Appeal Decisions

Appeal Ref: APP/R5510/C/21/3275179

Land at 105 and 105A Field End Road, Pinner, Middlesex HA5 1QG

Appeal Ref: APP/R5510/W/20/3266134

EXISTING LONG SECTION

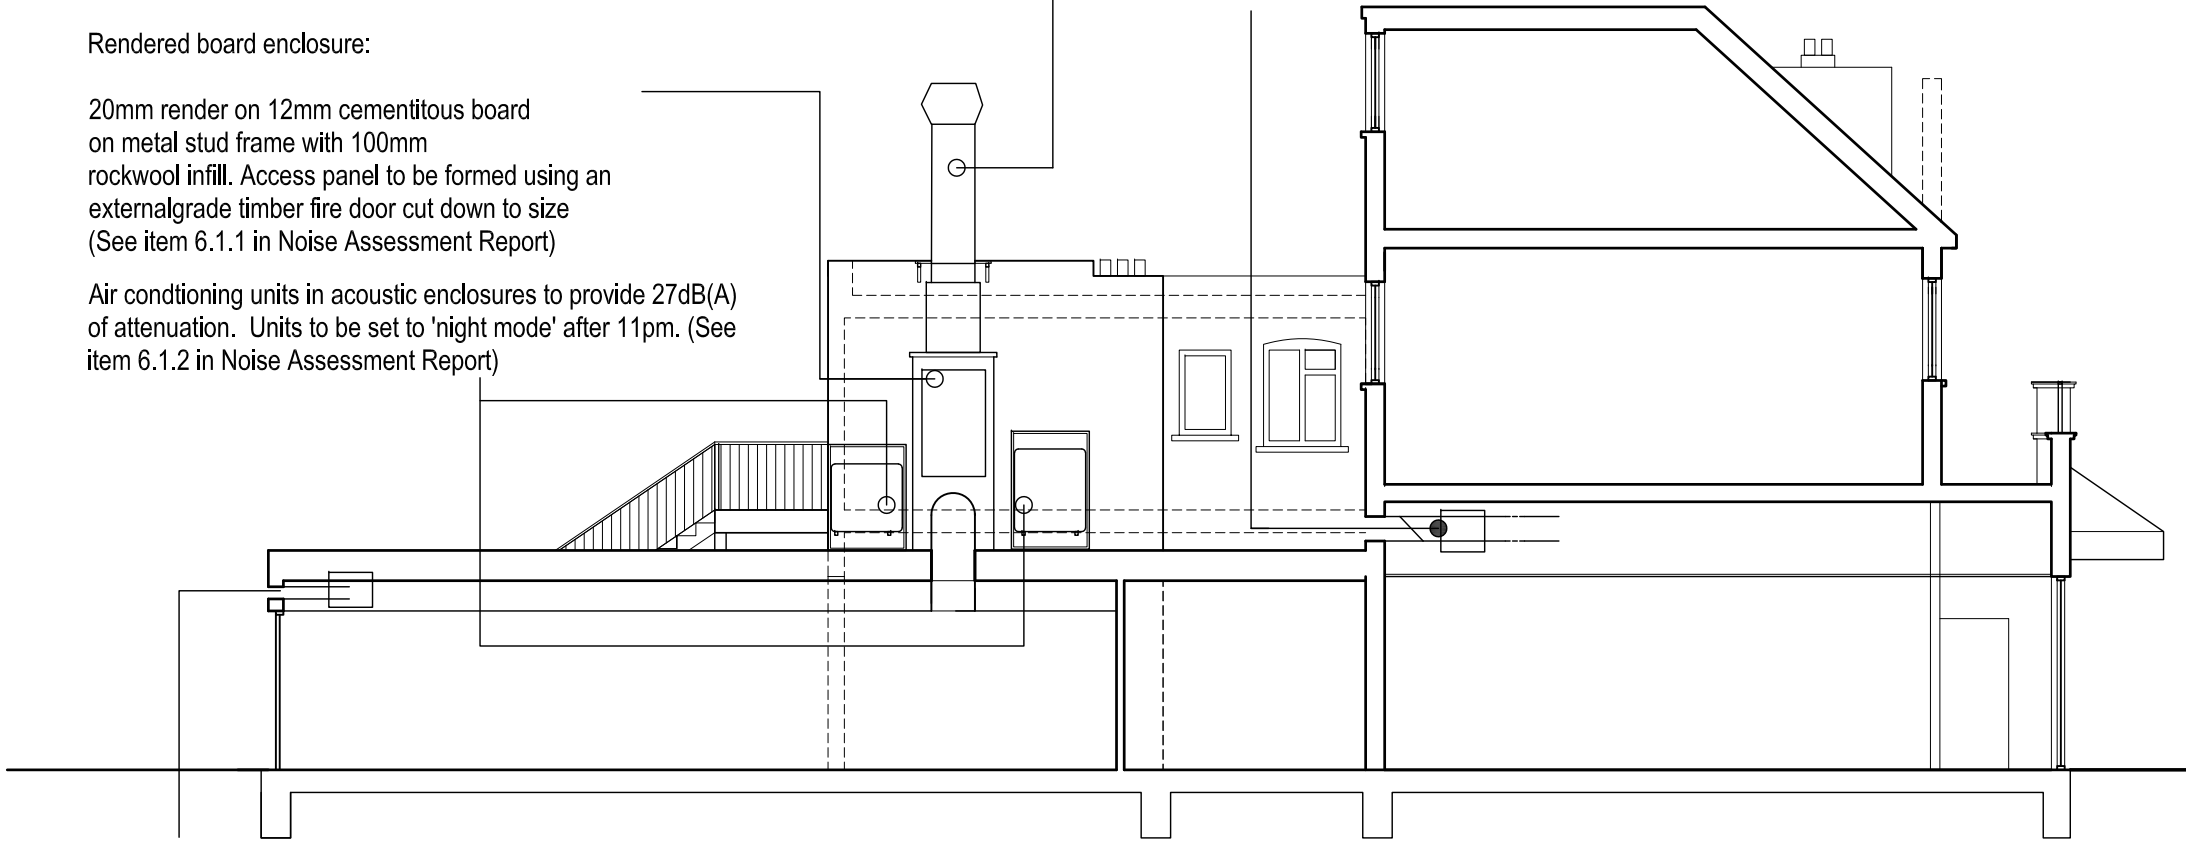
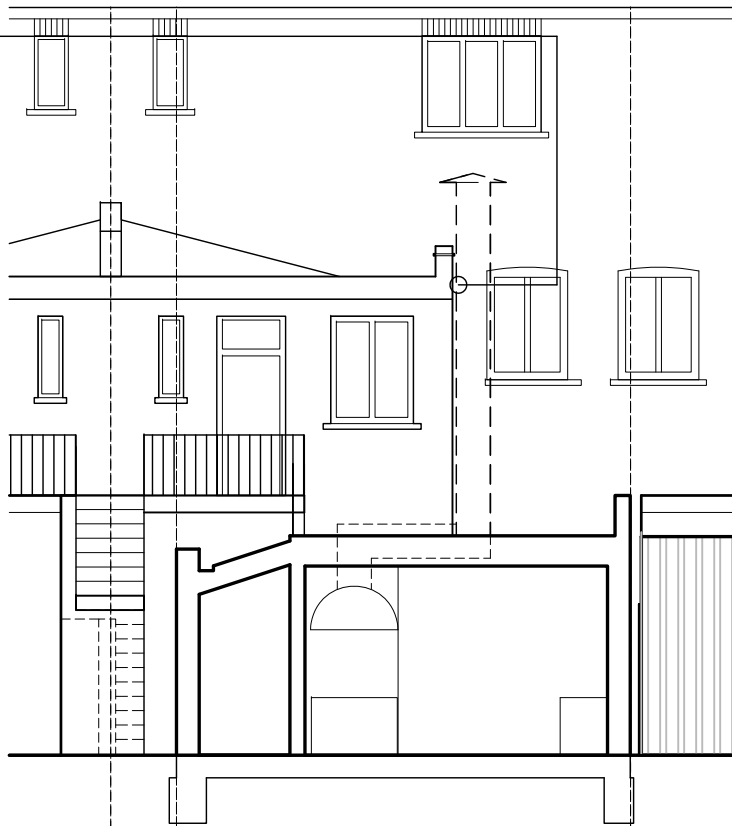
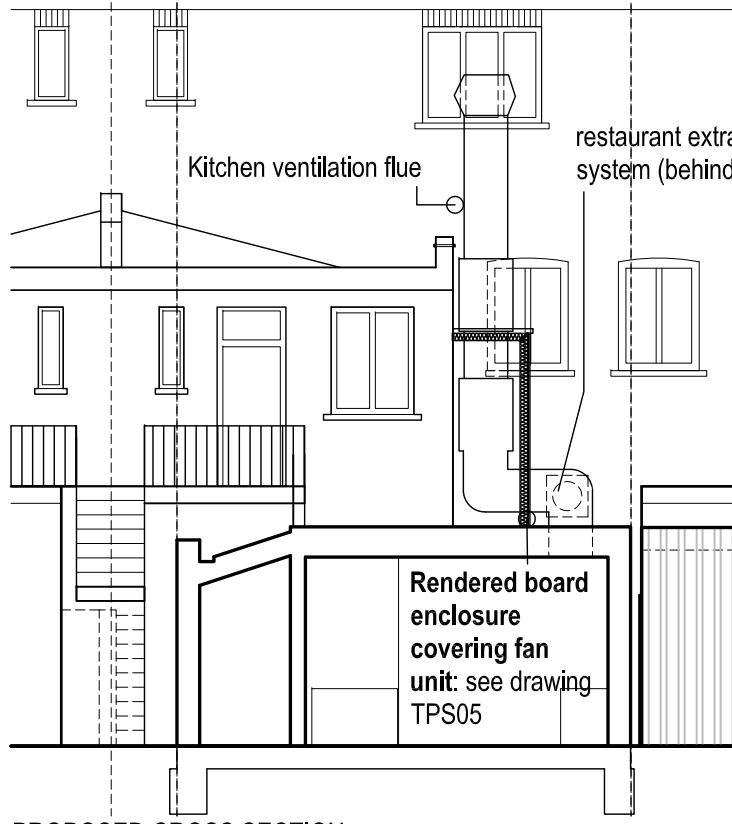
21. When in the room that has the blank wall to which the flue was attached, I was able to clearly hear noise from the plant. This was coming through the wall. Whilst the mitigation measures propose to enclose the Axial Fan, nothing is proposed between that fan and the blank wall. I cannot, therefore, be sure that this noise, which I find would cause significant annoyance to the occupants of the flat, would be mitigated. Furthermore, whilst the Axial Fan remediation treatment is provided in some detail, I do not have the same level of detail for the enclosures around the AC units.

27. The AA report for the Council finds that, if implemented in full, the mitigation measures would overcome the current odour problems. However, as it says, the various drawings submitted by the Appellant do not illustrate whether, what and where the mitigation measures would be put in place.

31. Windows serving flats and a maisonette at Nos 105 and 103 look out onto, and across, the flat roofed area where the plant has been installed. From these, the flue and AC units are clearly seen.
32. Using the scale bar on Drawing TPS04/P2, the flue is set some 5m from the rear elevations of the dwellings. The lower portion of the flue, including its

Axial Fan, and the AC units are seen either against the wall of the first-floor projection or the flat roof above the restaurant. They have little effect on occupants' outlook, which would not be harmed were the AC units and Axial Fan to be enclosed in the manner proposed.

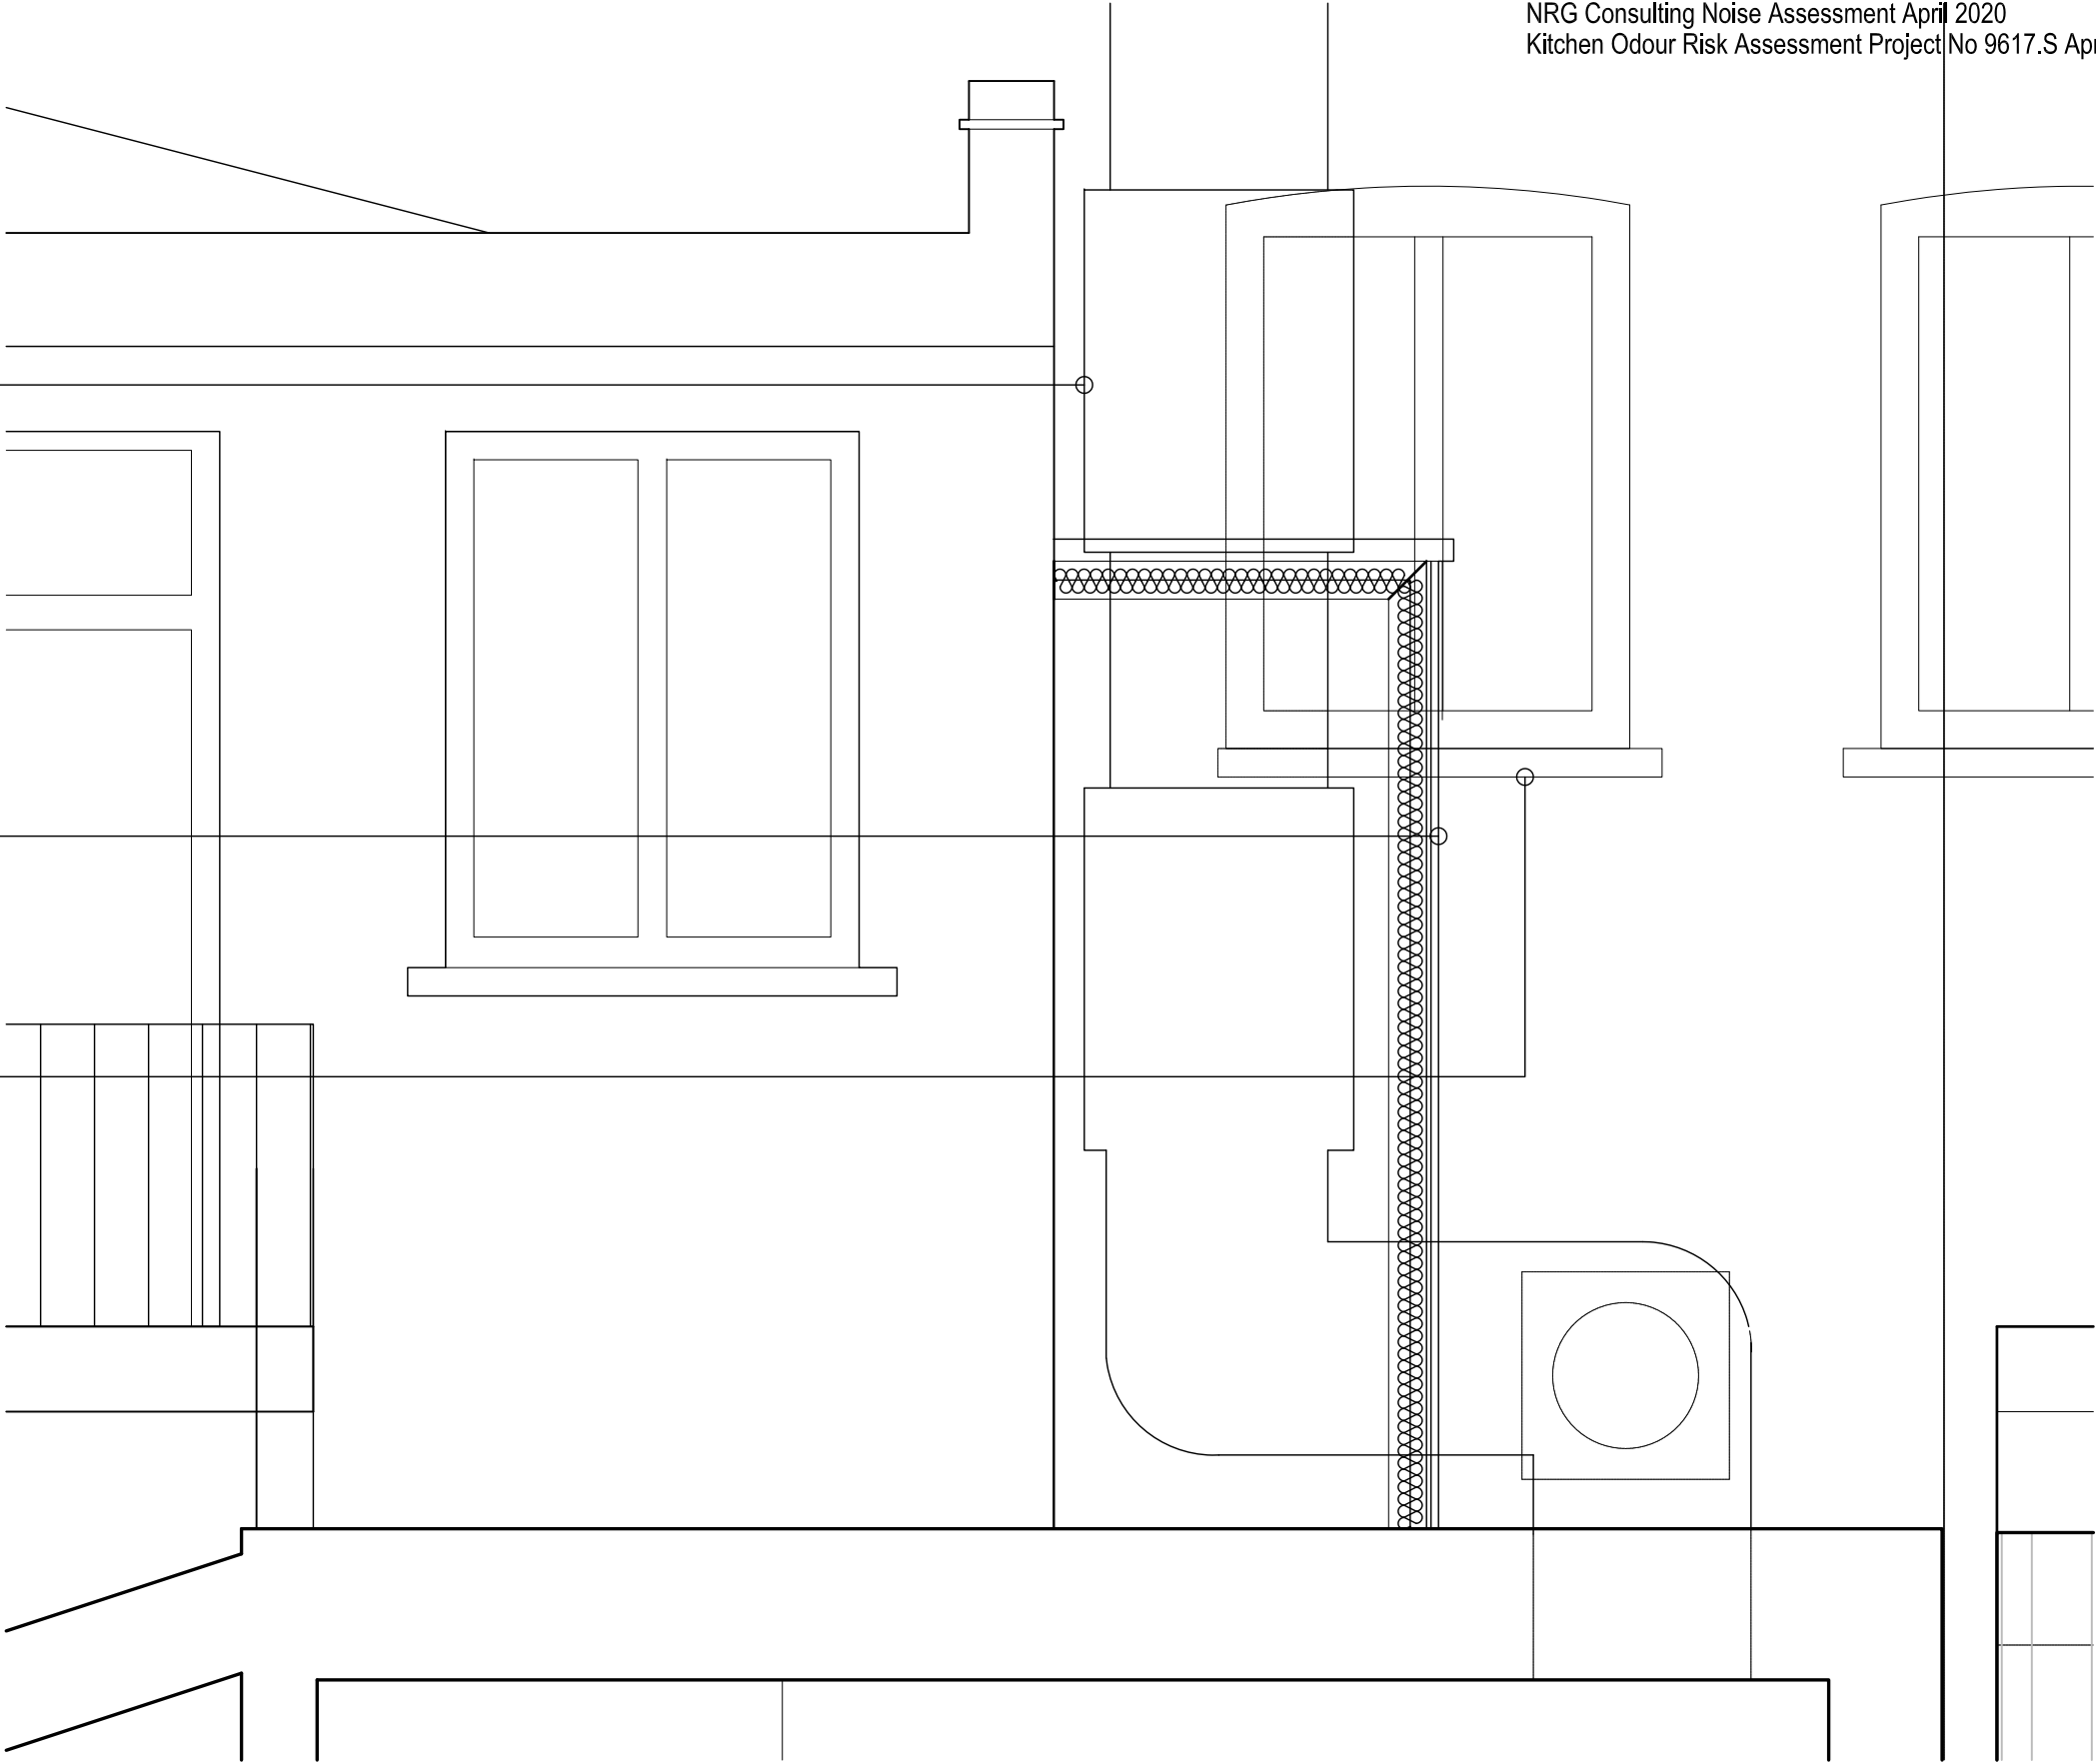
22. Although both the restaurant extraction fan and the kitchen fresh air fan are to be set inside, I have no details of what the proposed plant would be, whether it would fit where it is proposed to be installed, whether their proposed positions would be acceptable, and whether they would function in the required manner. This reinforces a problem that is common to all of the information given: it has not been fully demonstrated that what is proposed would be practicable and/or effective.
